DOC18/304331
SSD 7539

**Darlington Terraces Mixed Use Development, The University of Sydney (SSD 7539) –
Environmental Impact Statement**

Attachment A

1 WESTERN ROOF TERRACE
SCALE 1:100

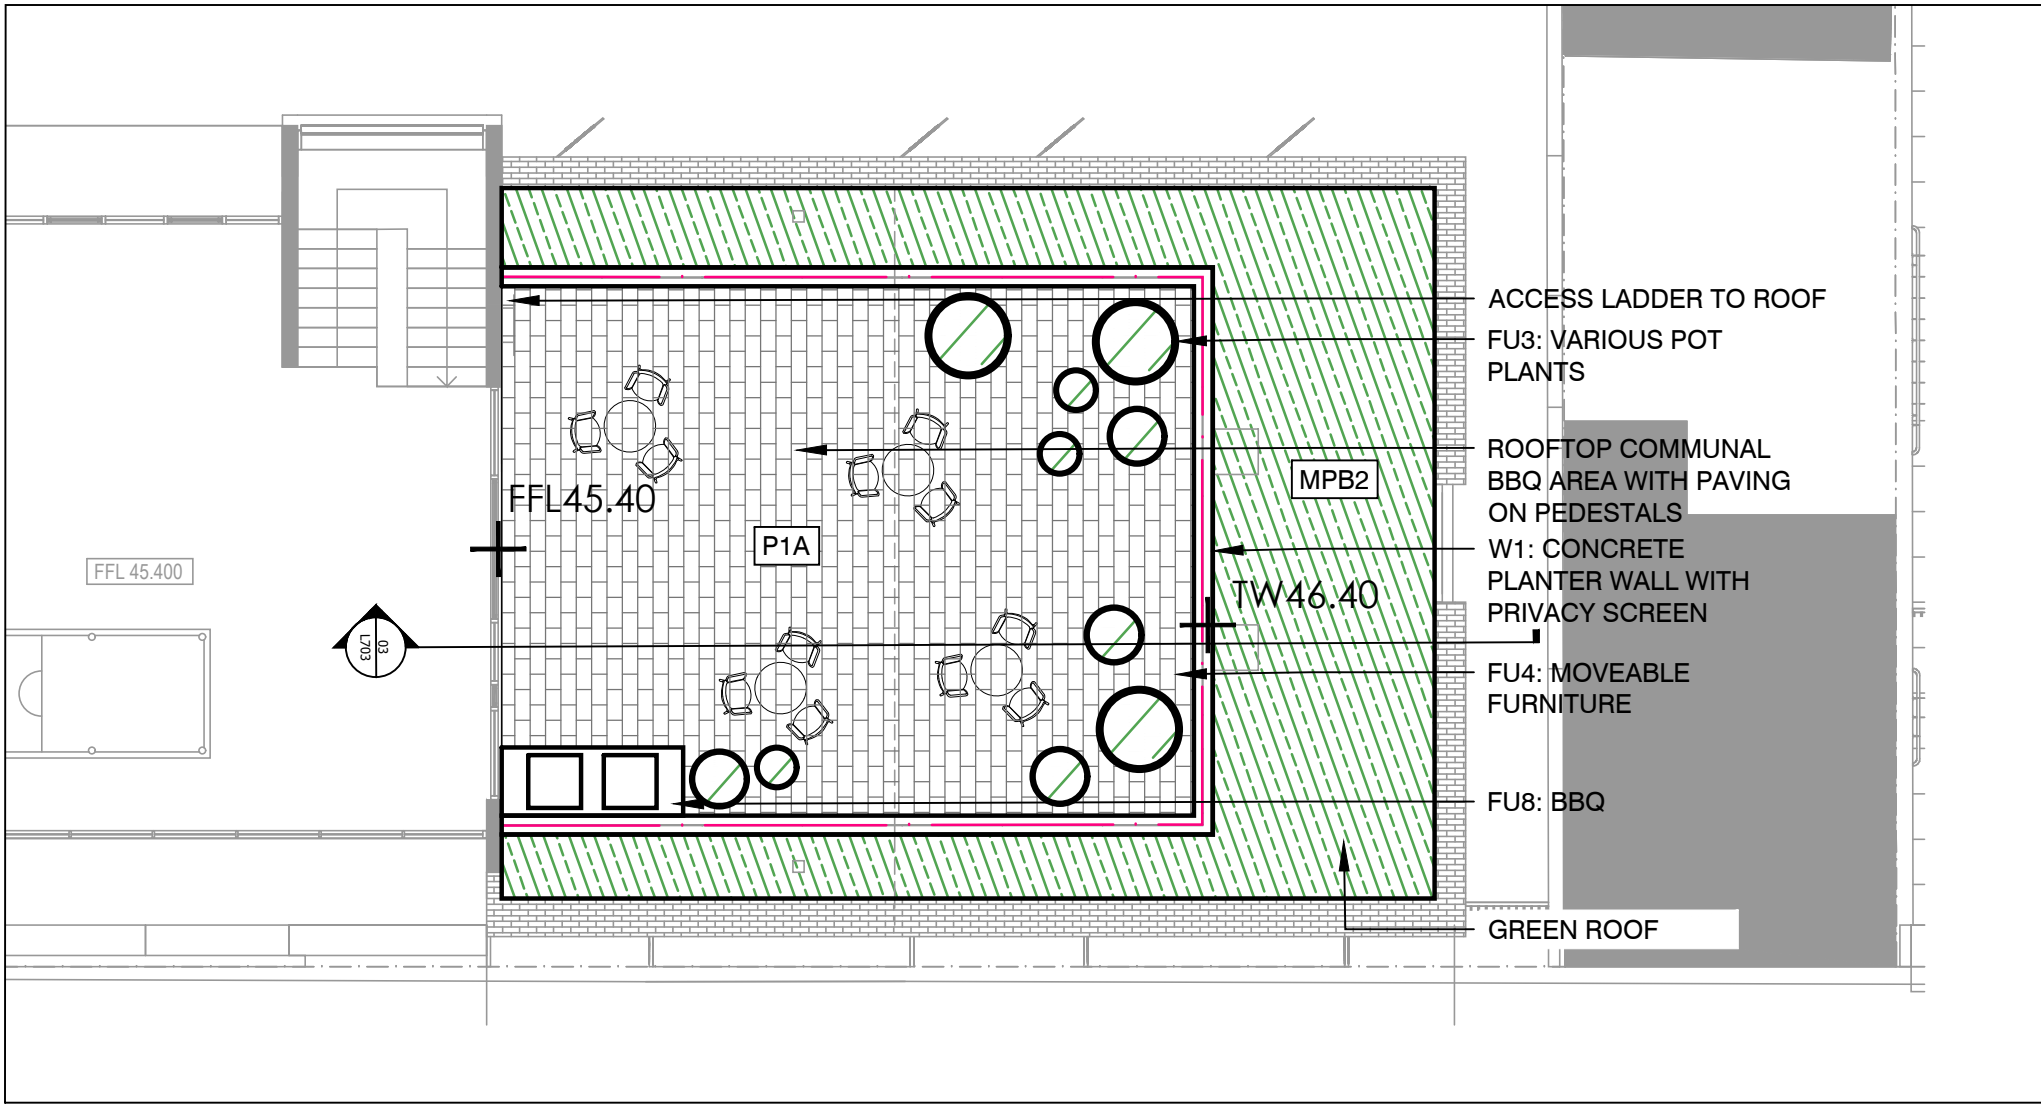
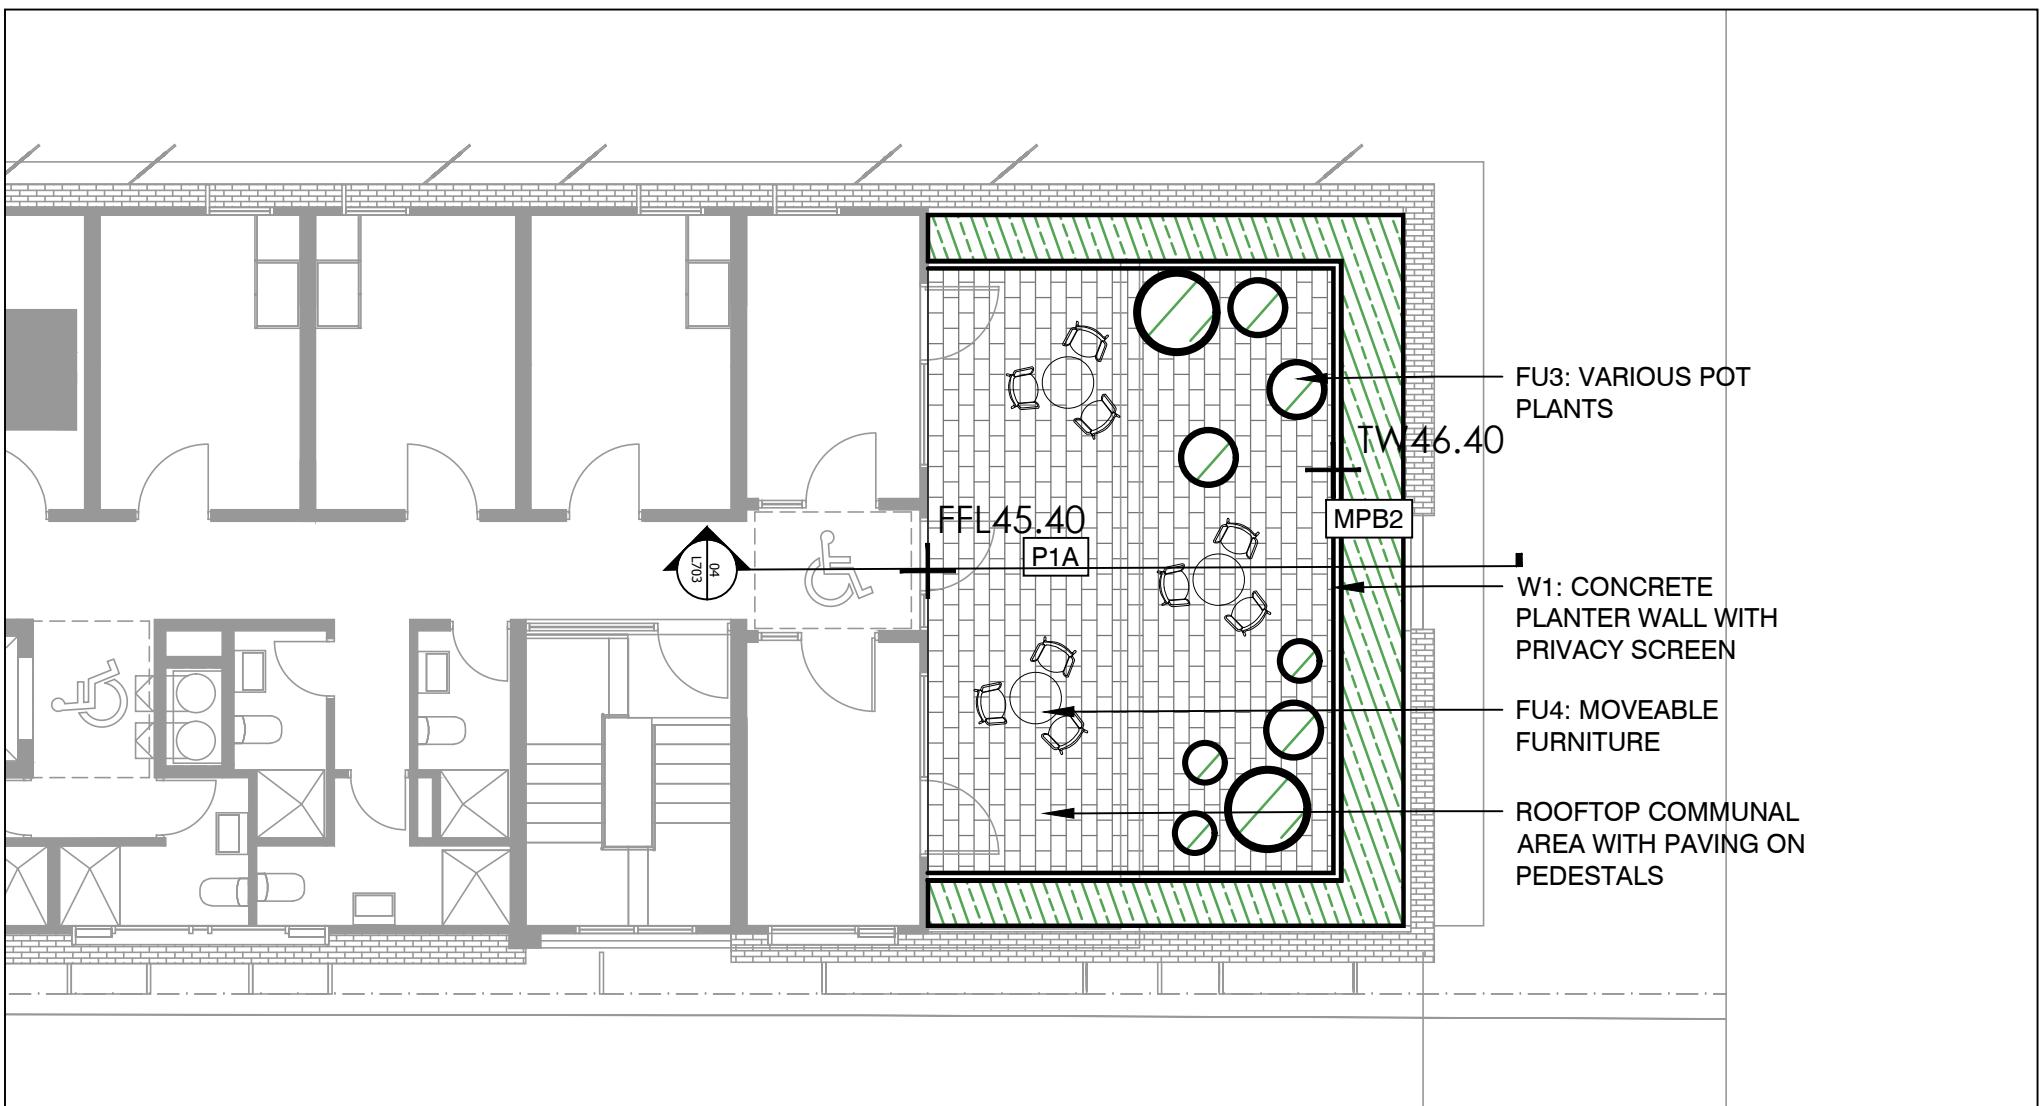
OEH notes a roof terrace is proposed on Building A and it includes a green roof (pages 31 and 32 of EIS). OEH encourages the buildings to incorporate a Green Roof or Cool Roof into the design. The benefits of Green Roofs and Cool Roofs are outlined in the OEH (2015) Urban Green Cover in NSW Technical Guidelines which can be found at the following link:

Green roofs are roof surfaces that are partially or fully vegetated. Cool roofs use reflective material to reflect and emit more solar energy than dark coloured roofs.

Green roofs and cool roofs can have a strong regulating effect on the temperature of roofs and building interiors, reducing the energy needed for cooling and the impact of the Urban Heat Island effect. The provision of an Intensive Green roof would increase habitat and biodiversity at the site, particularly if local native plant species are used from the relevant native vegetation community.
